**REQUEST**

Approximately 84.16 acres located on the north and south side of Sardis Lane, and east side of Providence Road.

The petition proposes a mixed-use development on parcels that are currently developed with multi-family, commercial, outdoor and indoor recreation.

Levine Properties

SHEET TITLE
EXISTING RIGHT-OF-WAY TREE PLAN

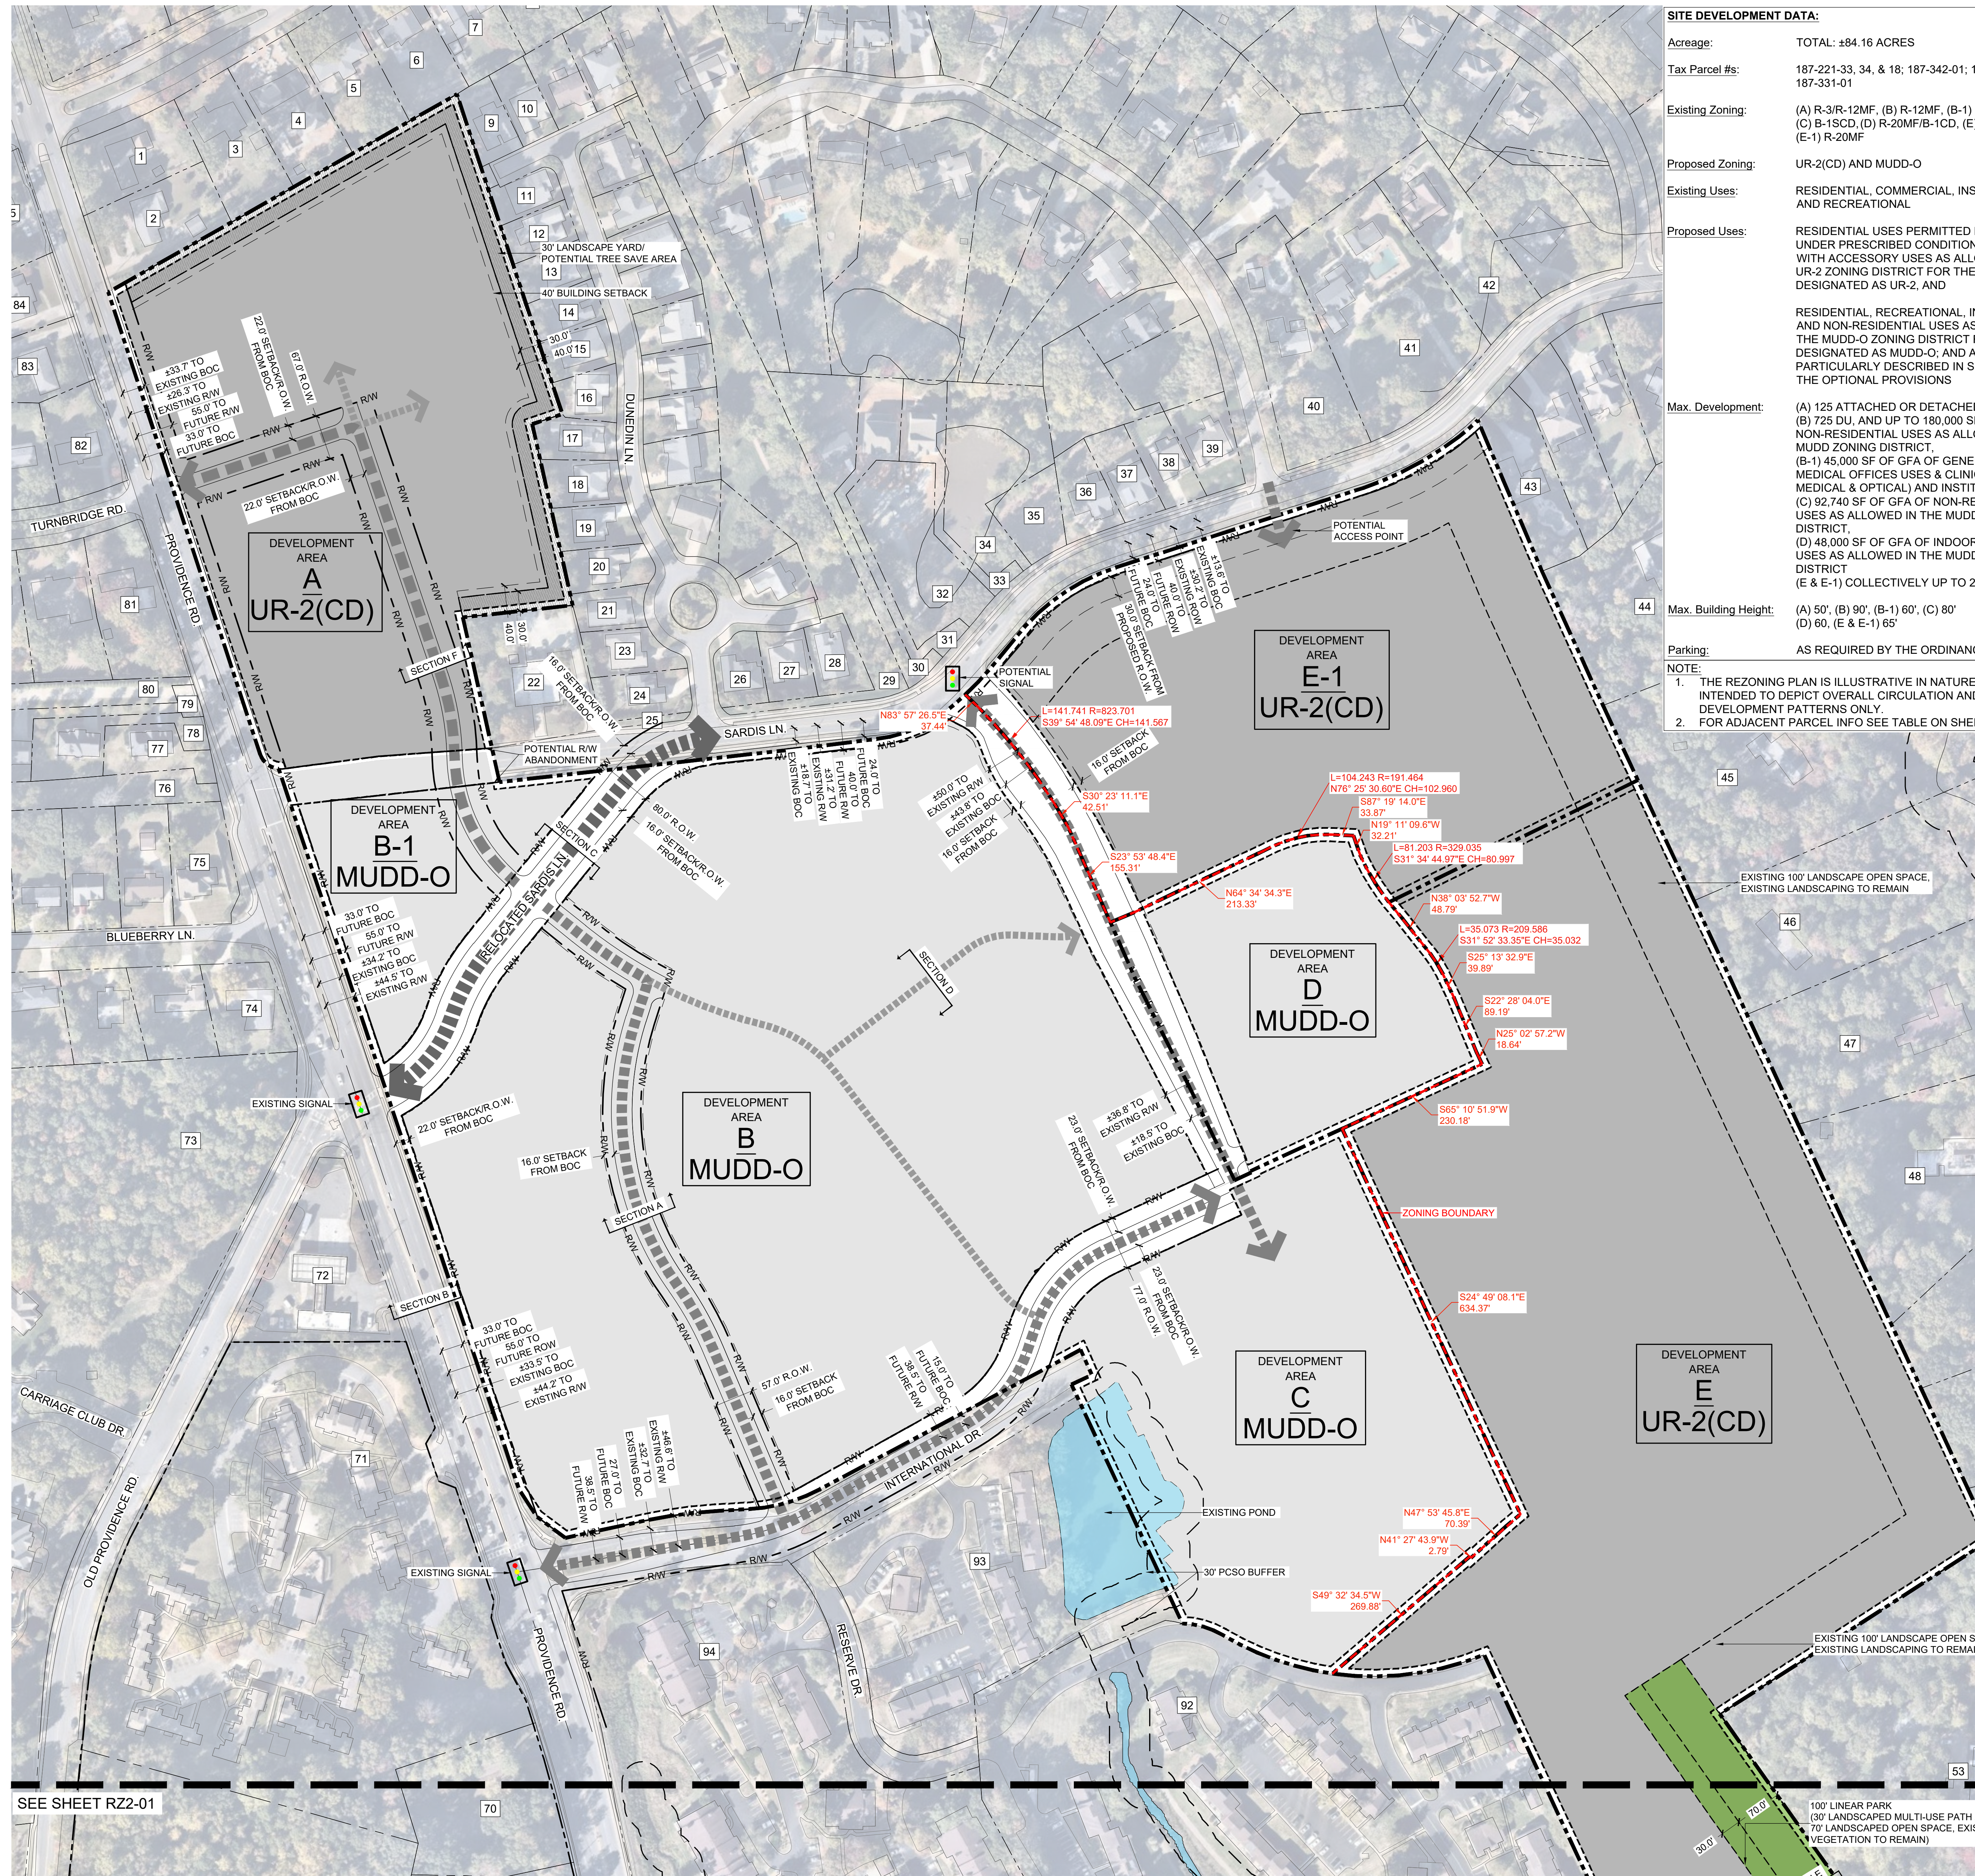
4. Stormwater: Address open conditions in Accela Plan Room relating to storm water quality treatment, volume and peak control.
5. Urban Forestry: Show required 15% minimum tree save area on site plan.
